Representation by EDF Energy (Thermal Generation) Limited (“EDF”) in respect of the Cottam Solar Project DCO Application (the “Project”)

This relevant representation is submitted on behalf of EDF Energy (Thermal Generation) Limited (“EDF”) requesting that EDF is treated as an Interested Party for the Examination of the DCO application for the Cottam Solar Project (PINS reference EN010133) (the “Project”).

Land Plans - Onshore
Sheet 19 of 19

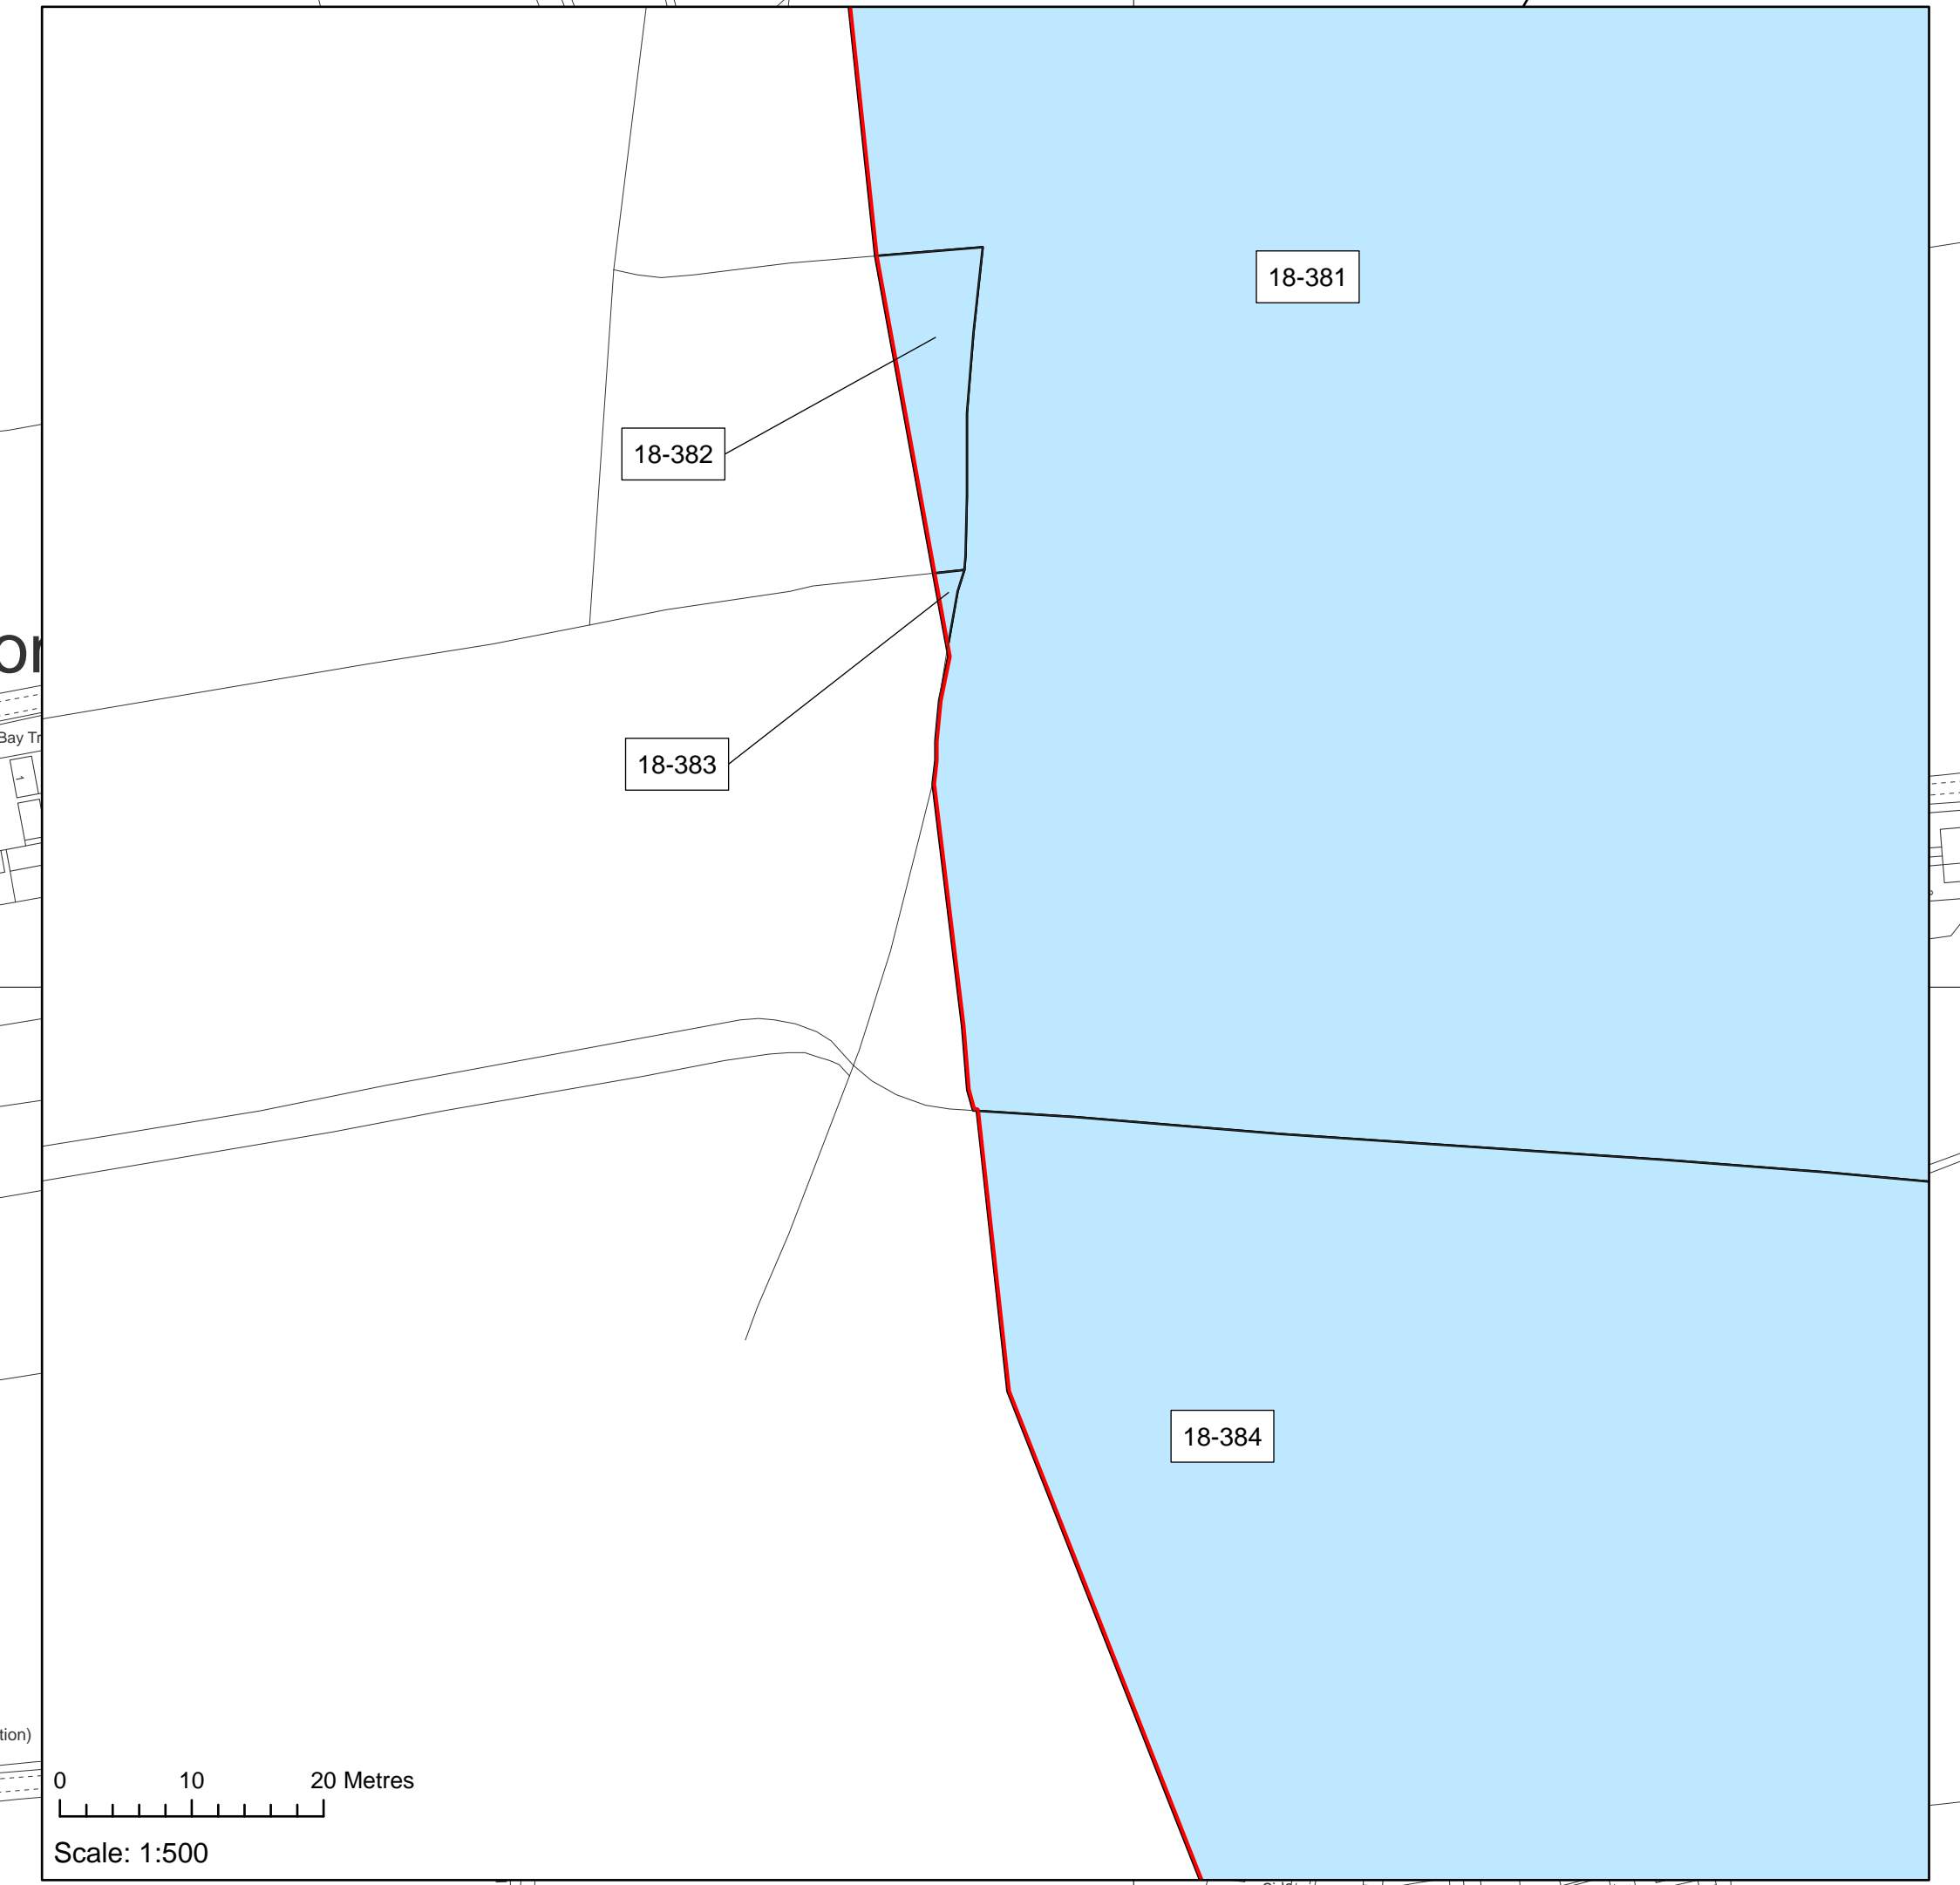
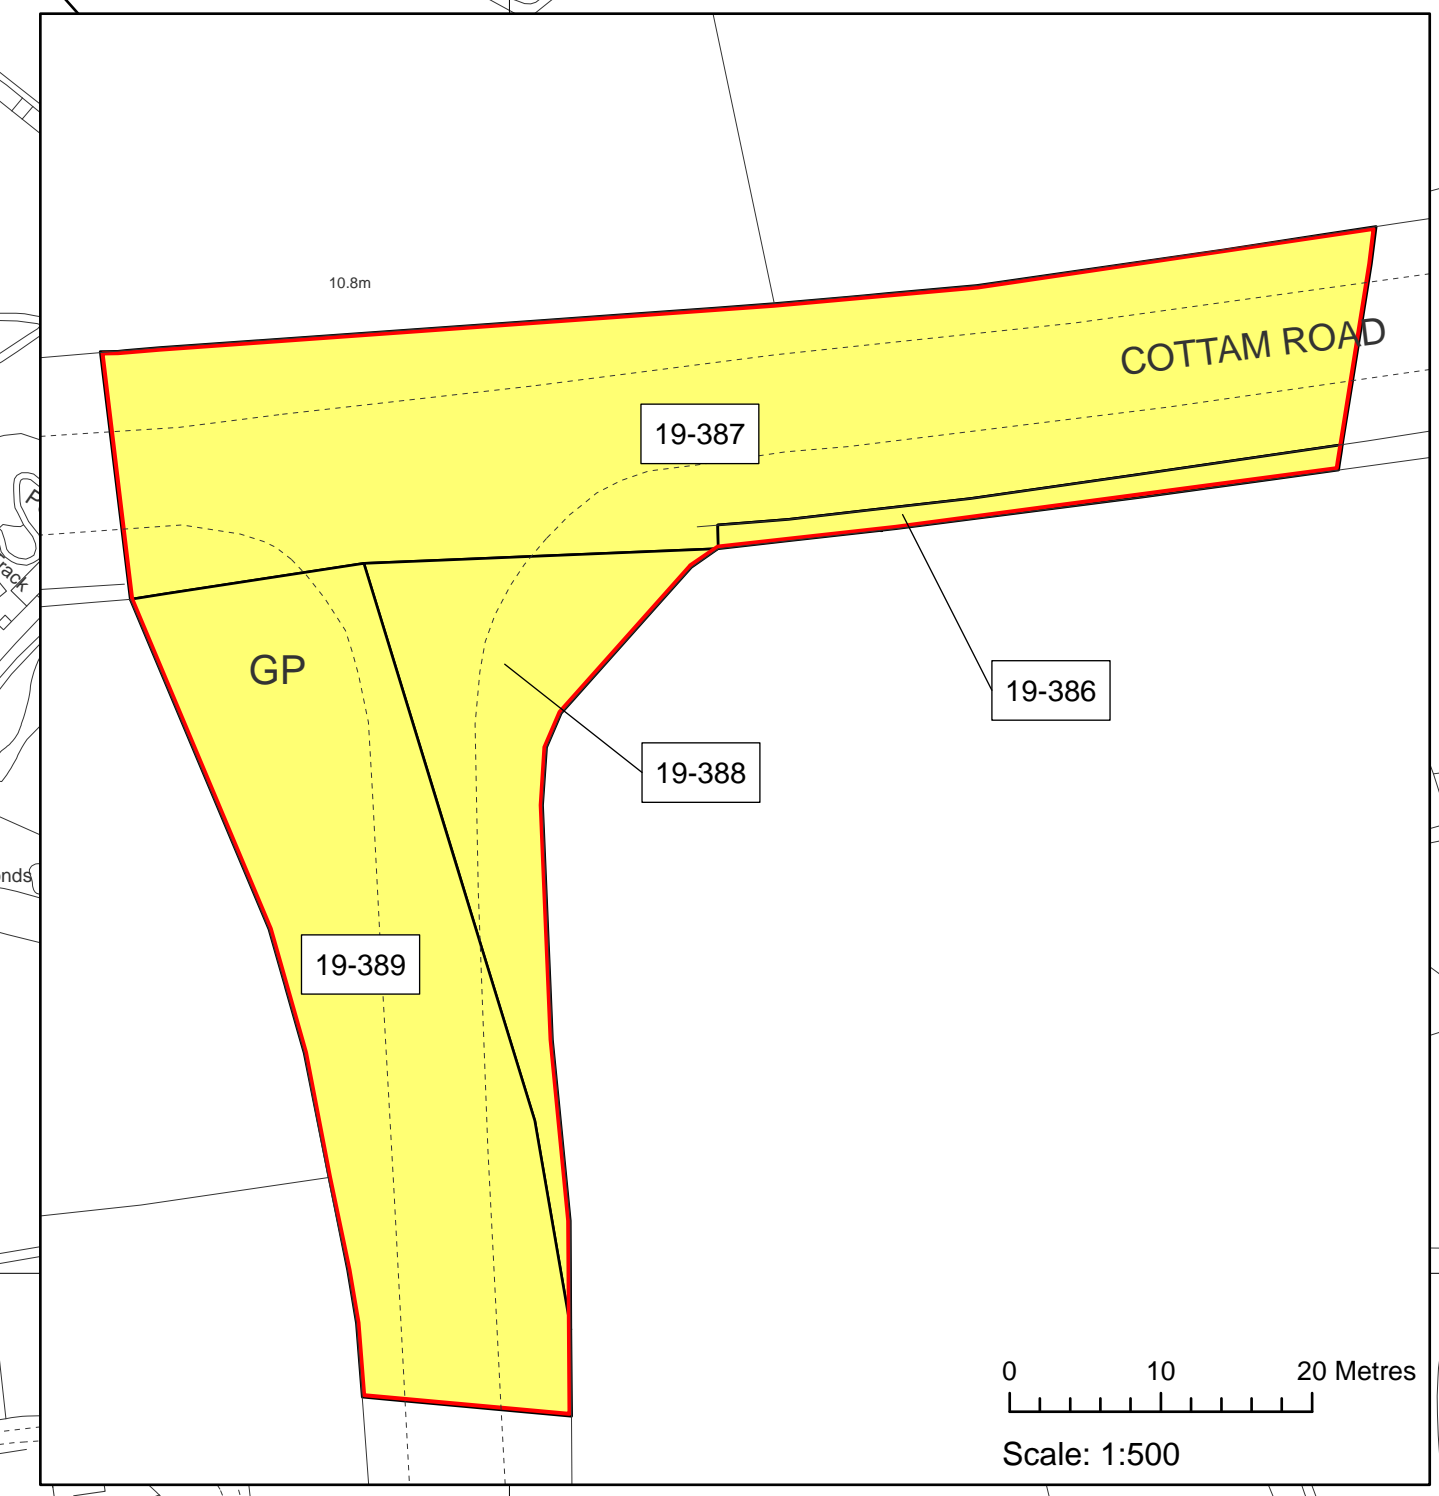
The Book of Reference (“BoR”) identifies plots 18-385, 19-390, 19-391 and 19-392 (the “EDF Plots”) as land owned by EDF over which compulsory acquisition powers to acquire new rights and imposition of restrictions are sought. To safeguard EDF’s interests, and the safety and integrity of the ongoing decommissioning and continuing operations, EDF objects to the inclusion of the EDF Plots in the DCO and the compulsory powers in respect of such plots.

EDF will require appropriate protection to ensure that the Project does not jeopardise continuing operations (including those of the CDC) or site decommissioning and demolition. EDF’s rights of access to inspect, maintain, renew and repair such infrastructure must be maintained at all times and access to inspect and maintain such apparatus must not be restricted.

EDF are responsible for third-party critical infrastructure on the site (a make-up and purge line which supplies the CDC, a 400kV underground electricity cable and gas pipeline all owned by Uniper, underground and overground cables owned by National Grid, numerous cables owned by Western Power Distribution and potable water supplies). Any infrastructure or operations associated with the Project must protect this third-party infrastructure and be undertaken in full compliance with the terms of existing legal agreements and obligations.

EDF will require protective provisions to be included within the draft DCO for the Project to ensure that its interests are adequately protected and to ensure compliance with relevant safety, decommissioning and third-party obligations. Additionally, EDF recommend that a pre-commencement requirement be imposed under the DCO, if granted, related to the approval of the final cable routing and that EDF be a named consultee for subsequent discharge of such a requirement.
